Your Ref: OWPC16224
Our Ref: FG/162/17/PL 10-10-2017
Please ask for:
Mrs A Gardner

Demolition of existing detached garage & erection of 1 No. dwelling.
1 Upper West Drive Ferring

Thank you for your internet representation made on 9th November 2017 which has been recorded as '**an objection**' with the comments as follows:

EXISTING SITE PLAN 1:100

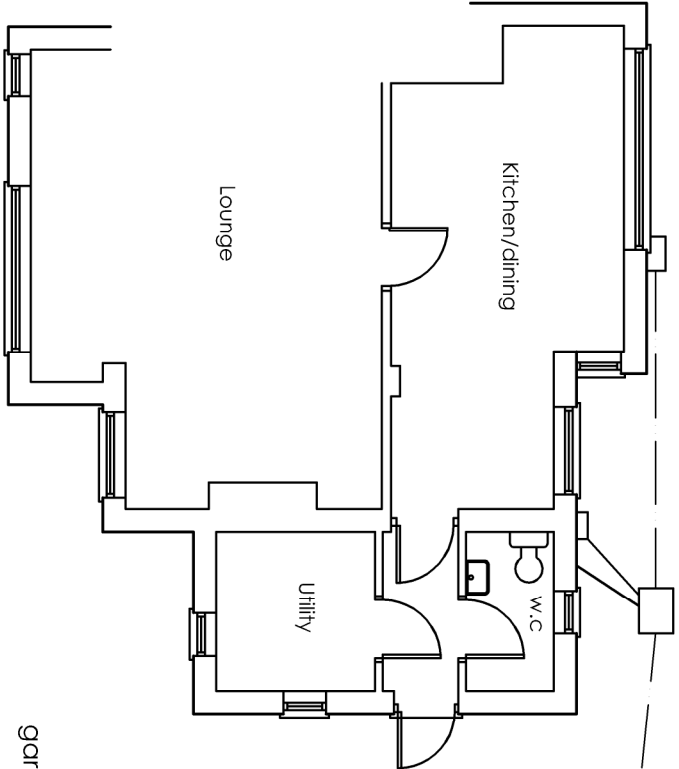
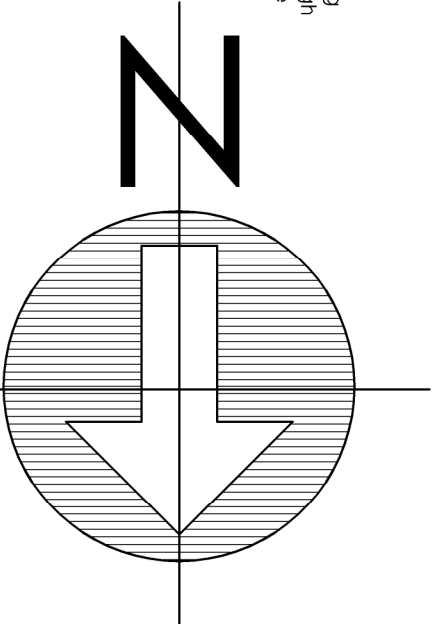
The proposed development is confined to a very narrow space which begs the question of how maintenance can be effected and more importantly safely managed. It would appear that this proposal is another example of over-development in a restricted area. We understand that the adjacent sycamore tree benefits from a TPO and this may be endangered if the development was approved.
